COLORADO
Department of Transportation

February 5, 2021

RE: Waterview North Sketch Plan Amendment - 2020-SKP
Traffic Impact Study - CDOT review, Master Development Drainage Plan - CDOT review, Soil,
Geology & Geo Hazard Report - CDOT review

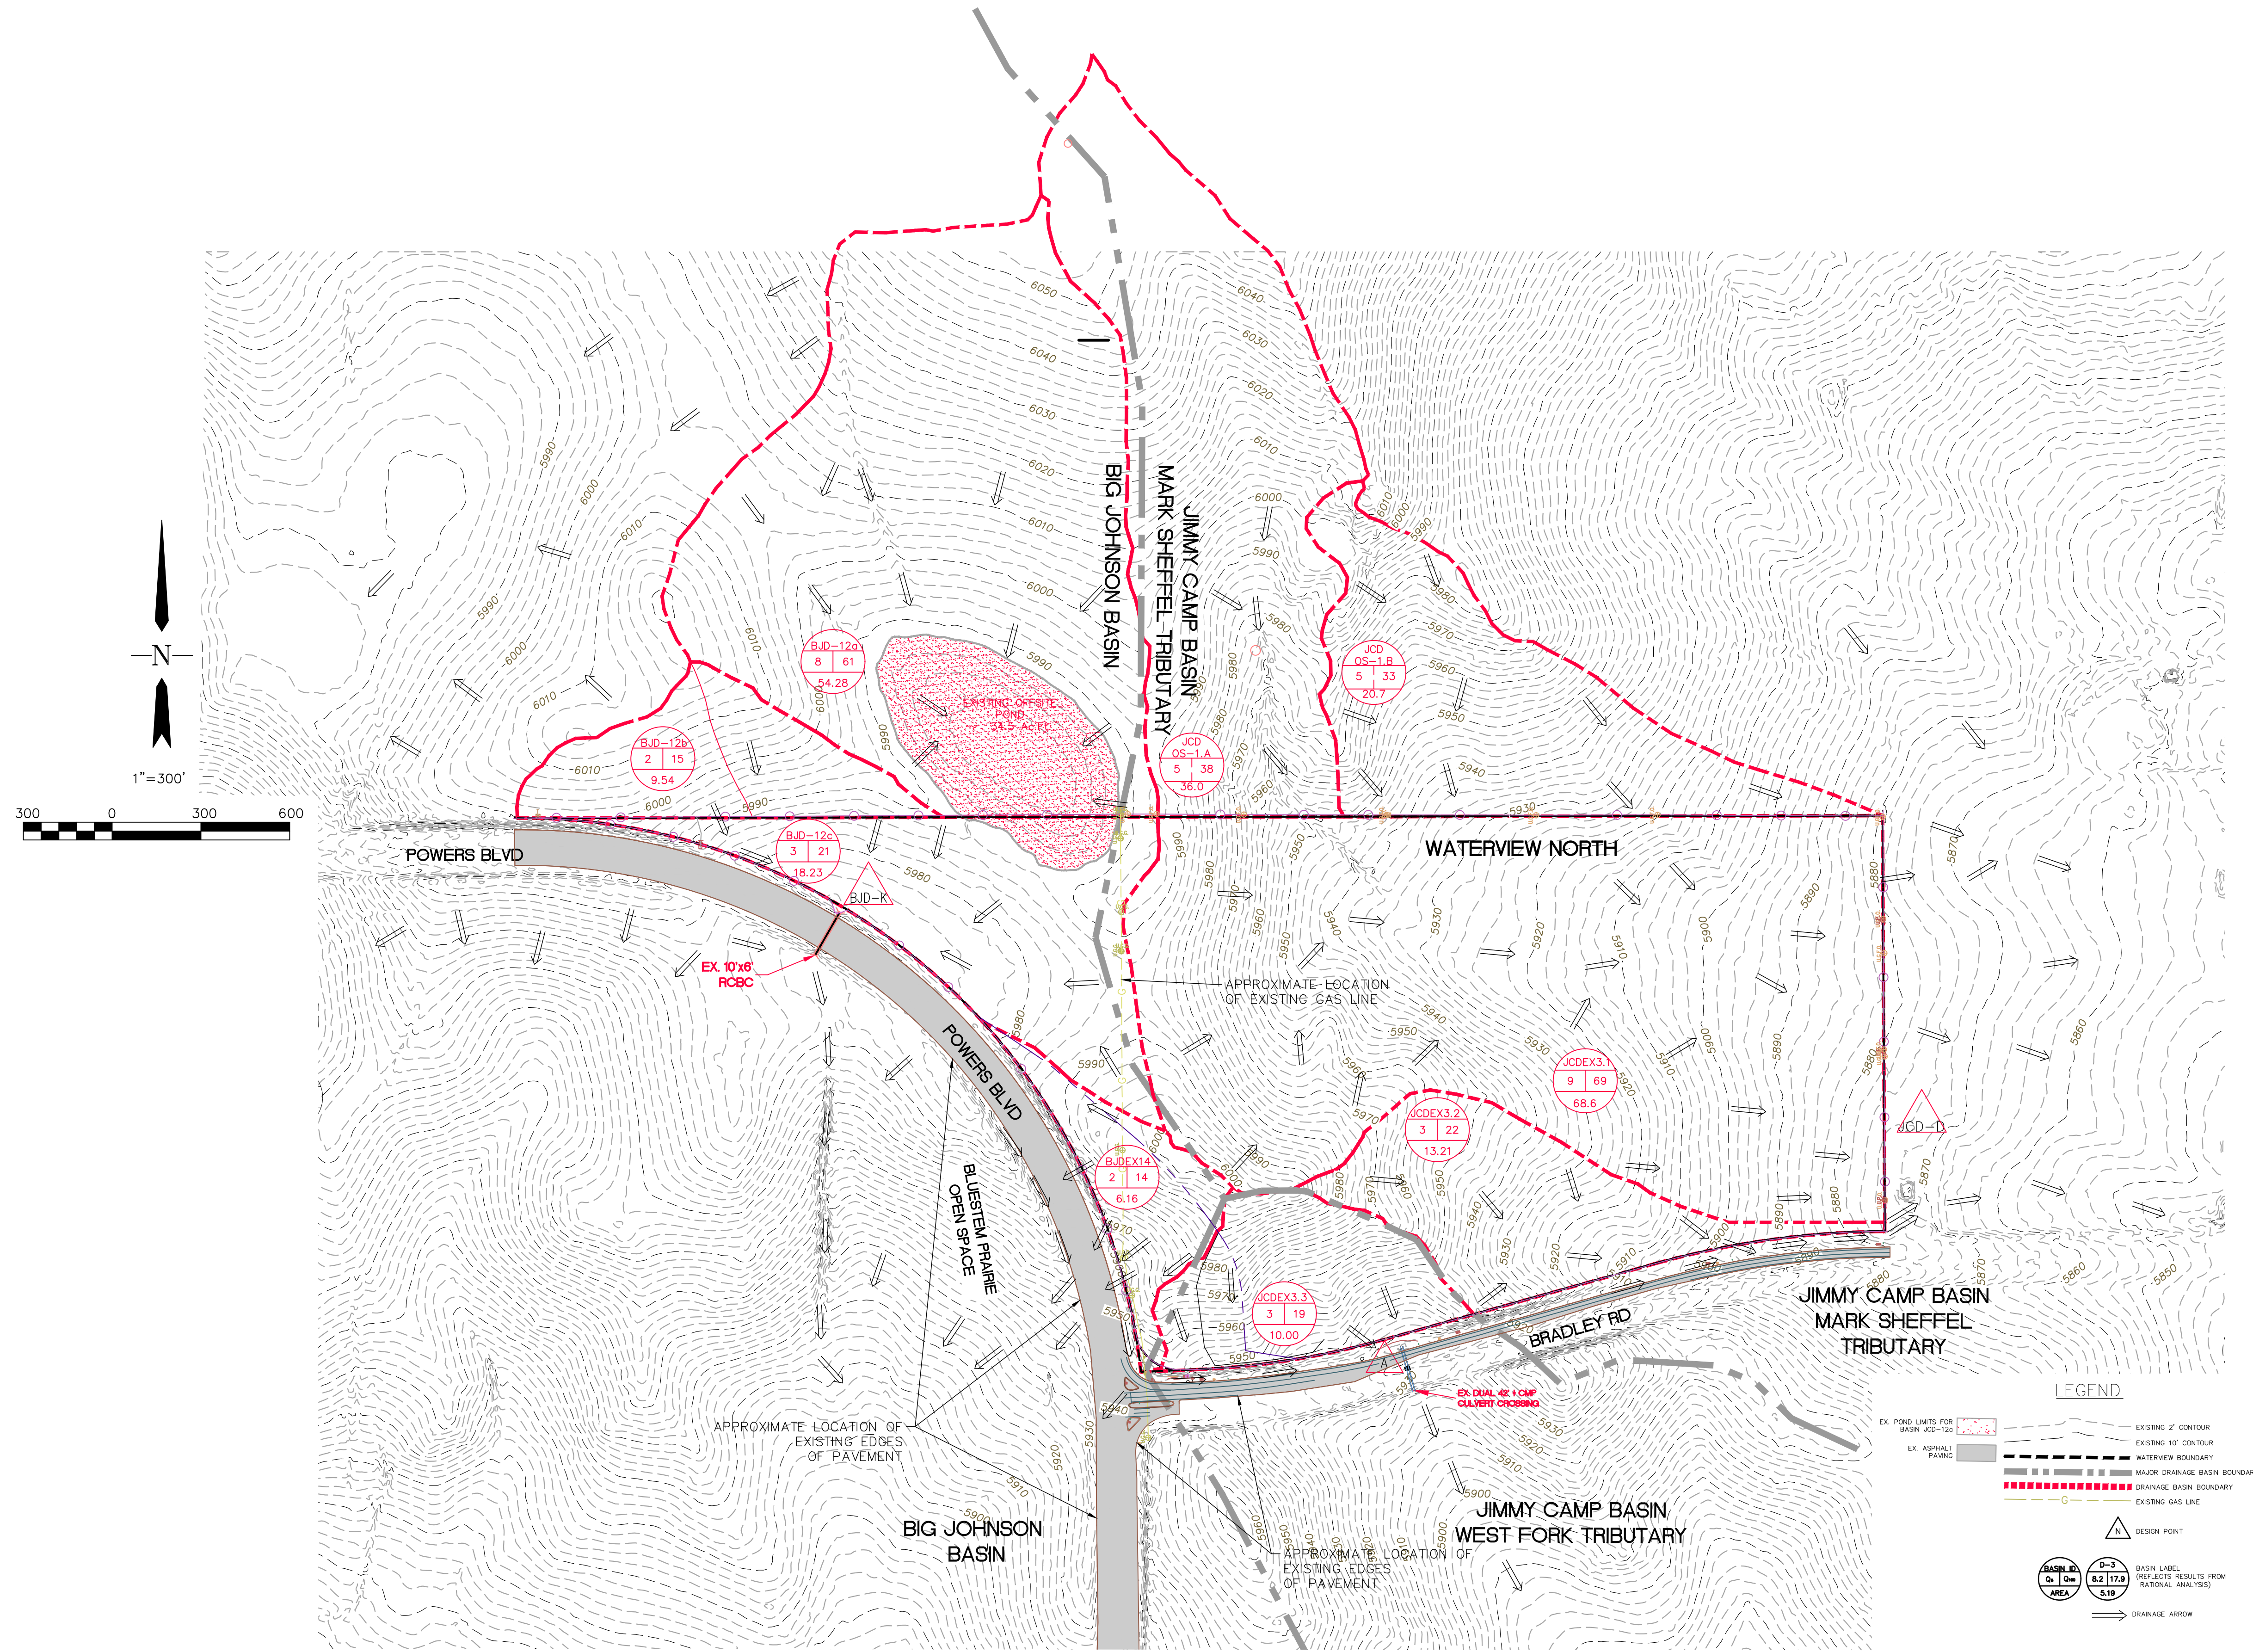
- o The report refers to a local depression (34.5 ac-ft pond) in Basin BJD-12a, and states that because of this depression, no runoff from this basin makes its way to the culvert under Powers. What happens to water that gathers there in the existing conditions? This area looks dry from aerial photos, so the water has to go somewhere. With Powers being lower in elevation than this basin, please provide more assurances to CDOT that this 54.28-acre basin does not contribute to the flows at Powers as stated.

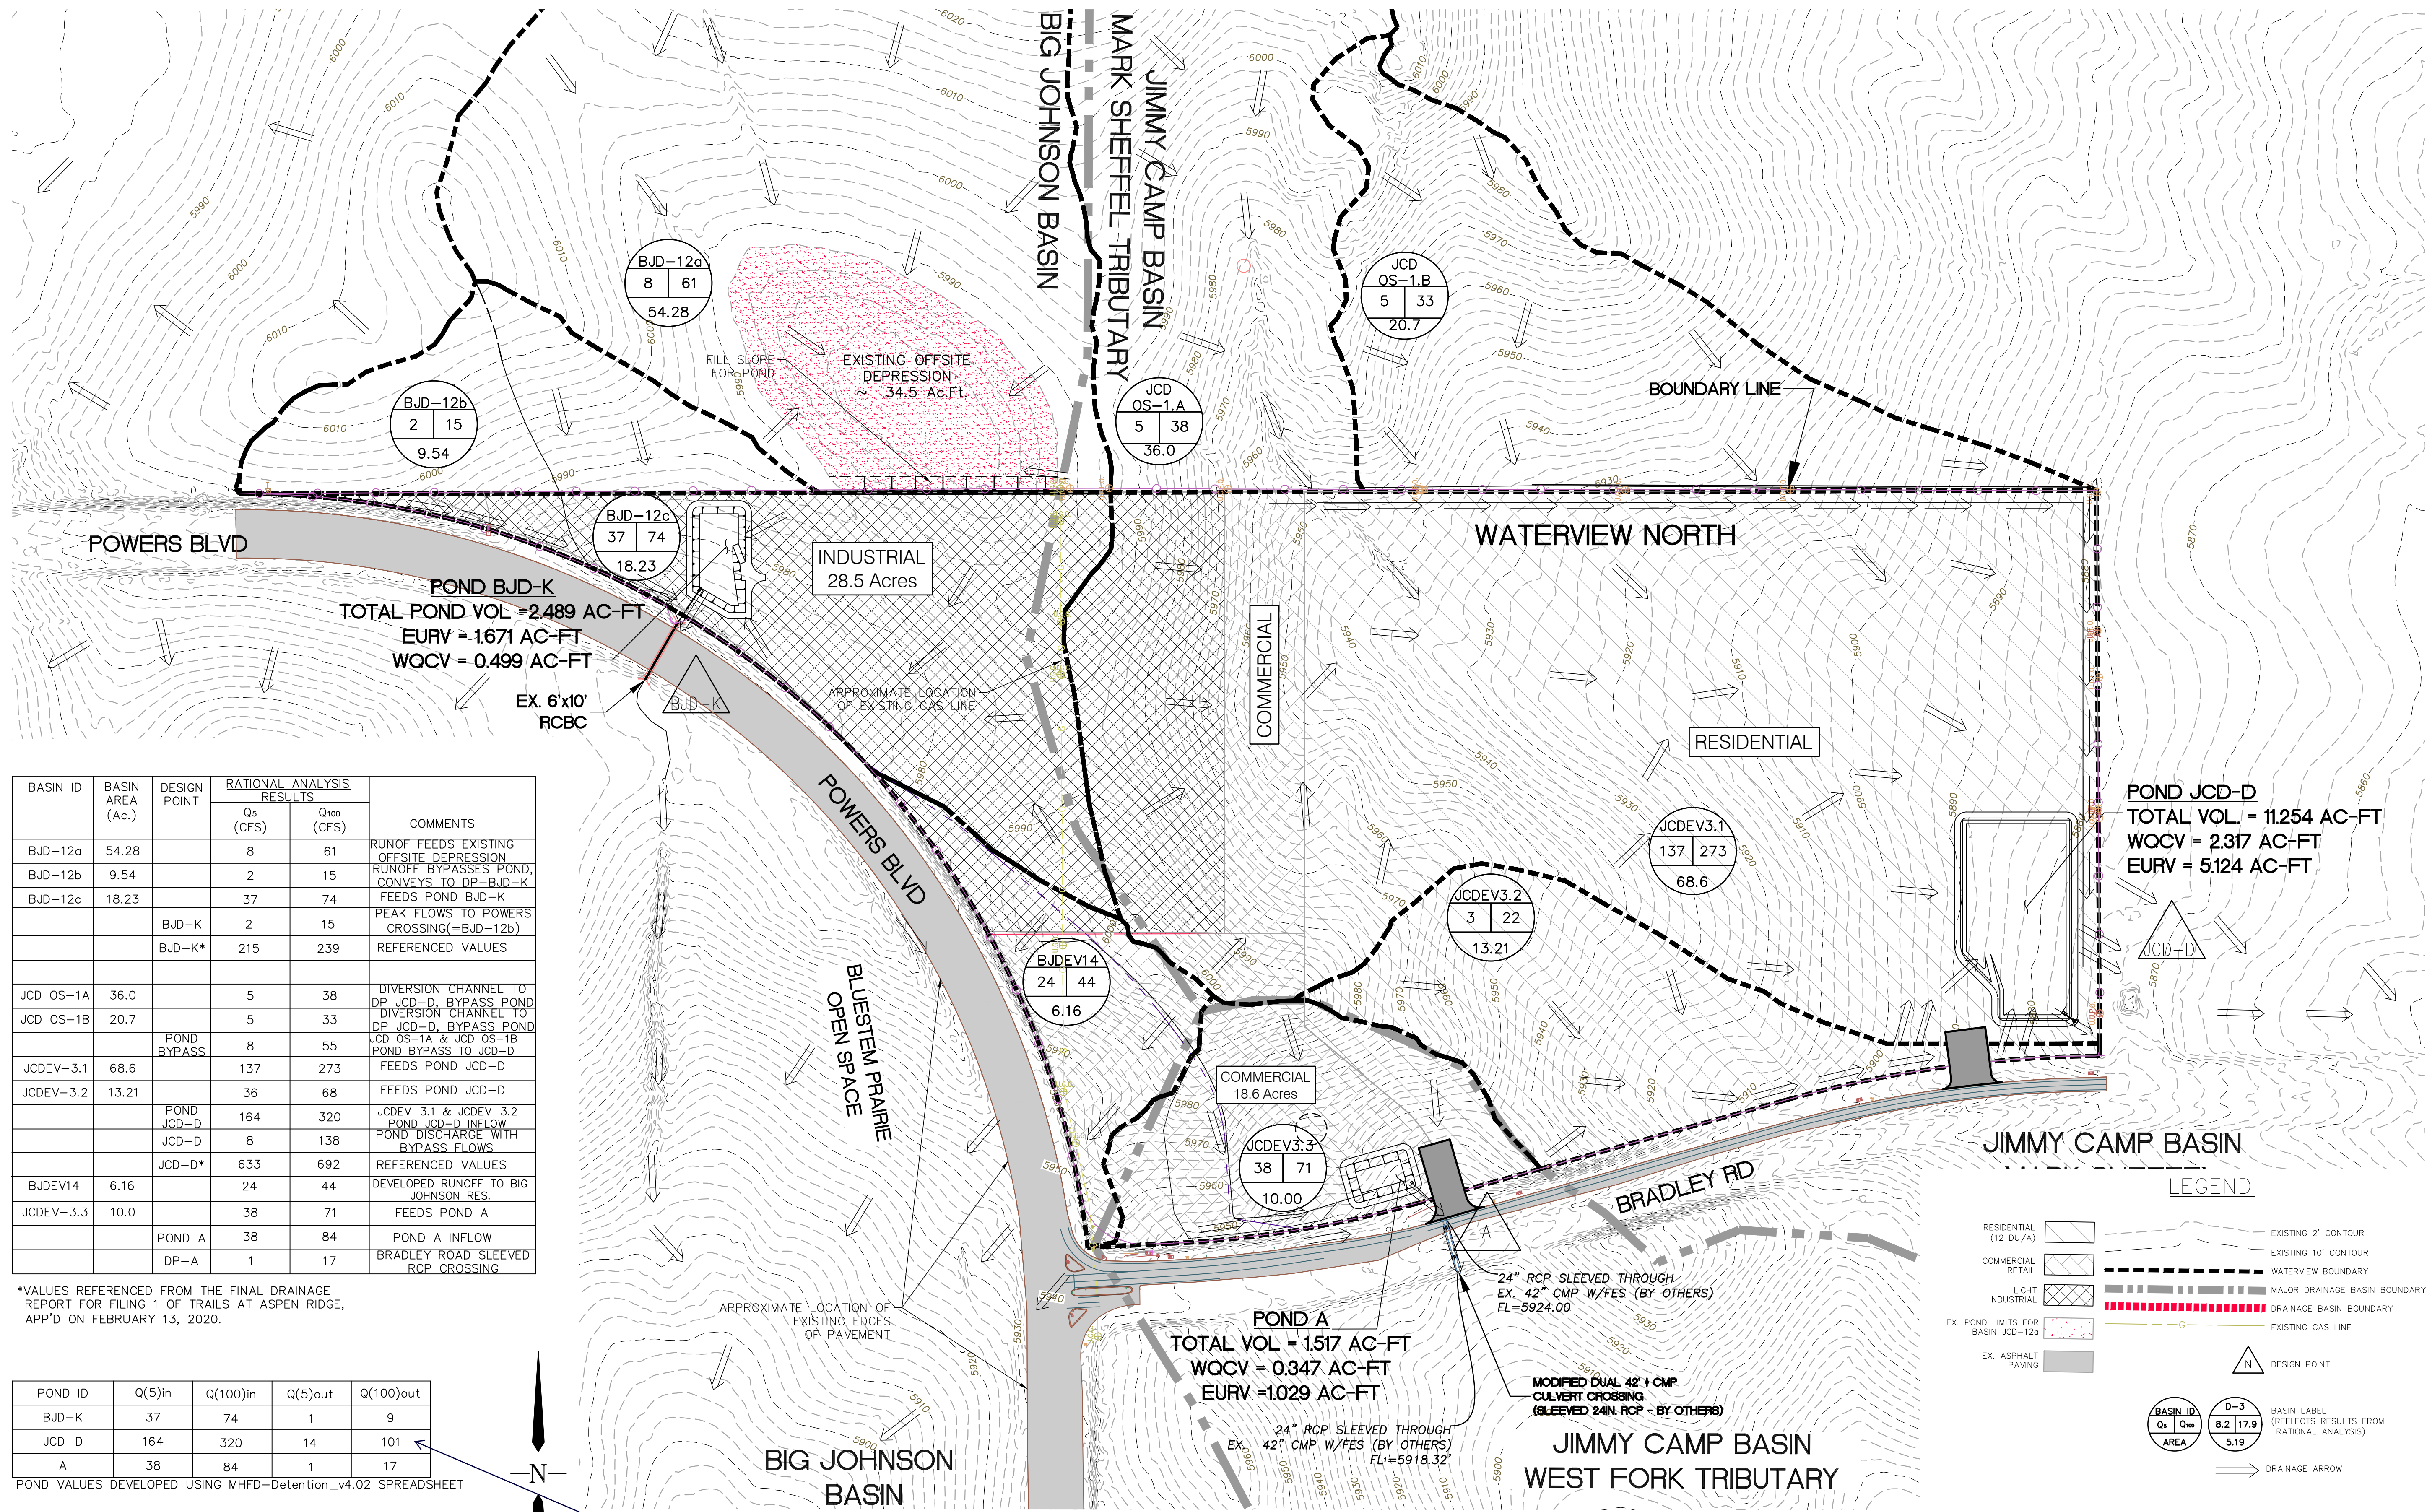
- o Please review the basin delineation for BJD-EX14 and BJDEV14. It appears that there is a roadside ditch that carries runoff around the corner and then east along the north side of Bradley. The report states that this flow sheet flows over Powers Blvd. which is not the case.

- o Better define diversion channels 1 and 2 that are shown in the appendix in the drainage map.
- CDOT Materials Engineer has reviewed the Soil, Geology and Geologic Hazard report dated May 15, 2020 and their comments are as follows:
